From: Anita Gardner <Anita.Gardner@arun.gov.uk>
Sent: 27 July 2020 09:46
To: Planning.Responses <Planning.Responses@arun.gov.uk>
Subject: FW: Wave Sculpture/Totem

From: Rachel Alderson <Rachel.Alderson@arun.gov.uk>
Sent: 24 July 2020 17:43
To: Anita Gardner <Anita.Gardner@arun.gov.uk>
Cc: Karen Liu <Karen.Liu@arun.gov.uk>
Subject: RE: Wave Sculpture/Totem

Drawing Title:
Plan & Elevation of Sculpture
Concrete Plinth

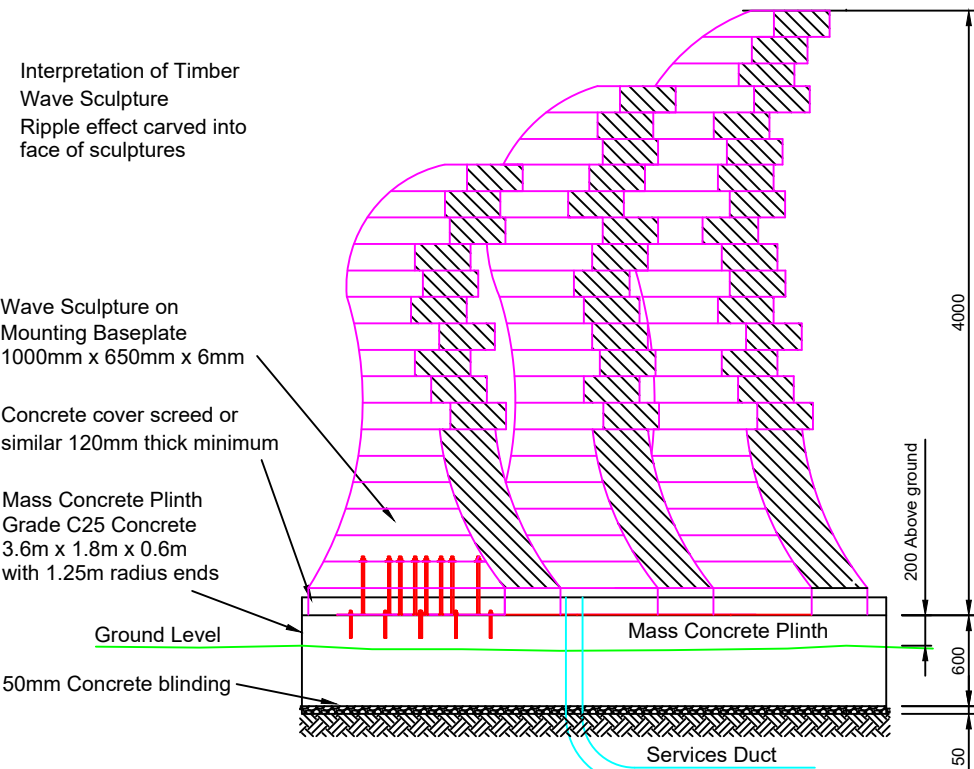
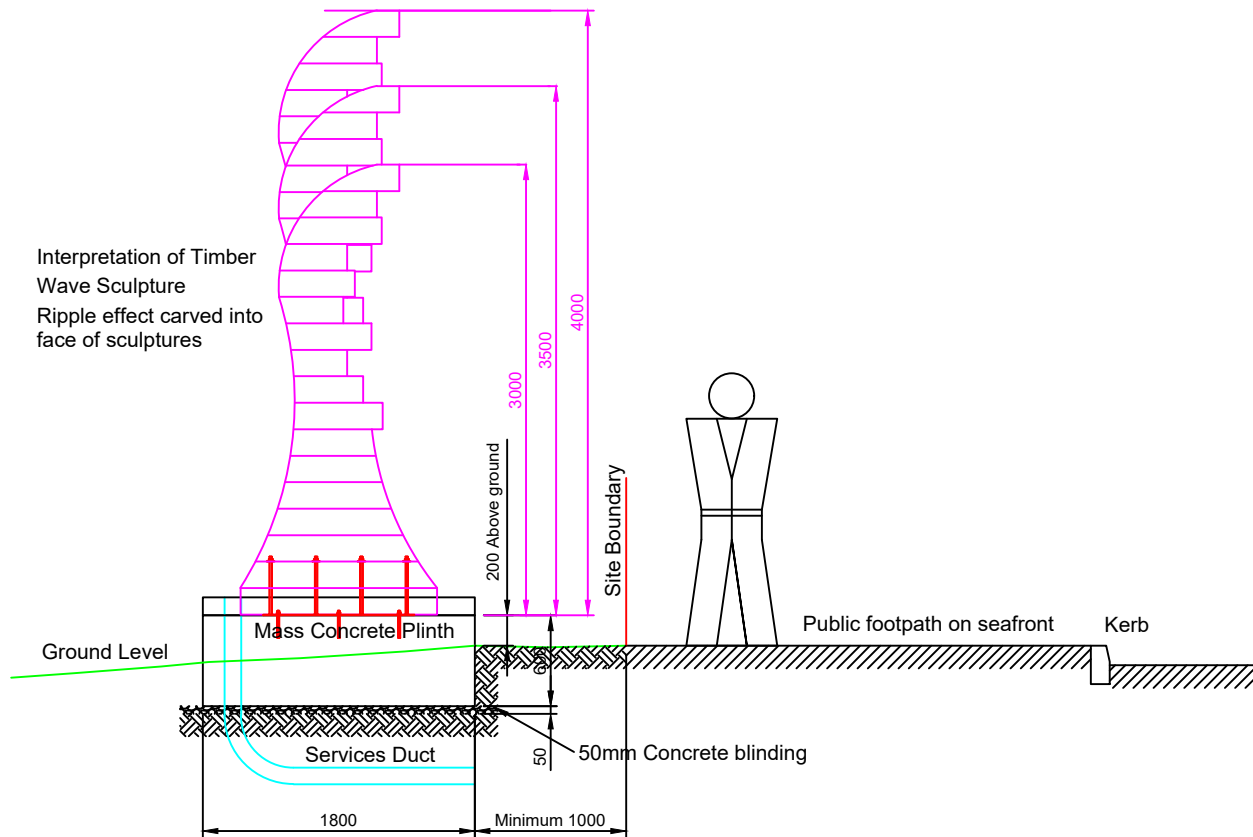
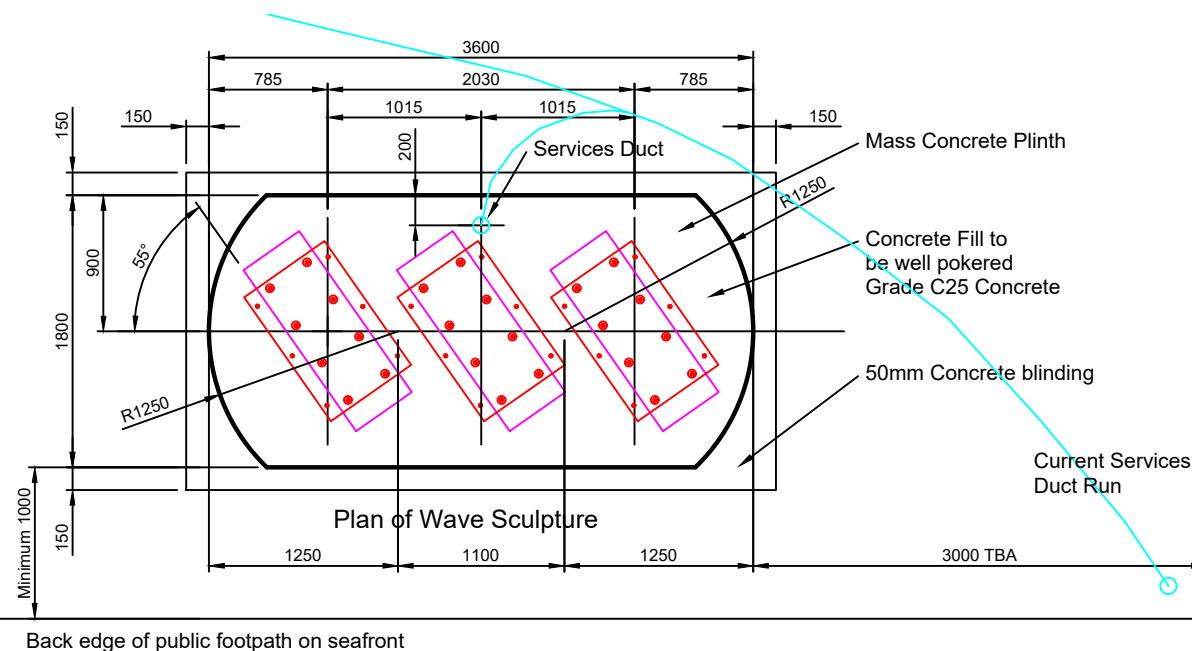
- Is it intended that the plinth would be painted? It would be much better if it were painted to fit in with the grass verge in which it sits. A big grey slab in this setting would be prominent. Does the slab need to be so large? Planting will be incorporated around all sides of the totem base to provide screening, and which will be an extension of the existing planting on site using the same species e.g. grasses etc. The slab needs to be

- The plan of the structure is completely different to the photo image which doesn't seem a true representation. Can you provide clearly labelled scaled elevations for each side of the sculpture and maybe other photo montages from other directions further away from the base of the structure. We are in the process of collating additional visual information to help respond to this query (see earlier emails).

the size it is, in order to provide enough space for the large fixings that the sculpture will attach to and accommodate the twisting of the sculpture bases.
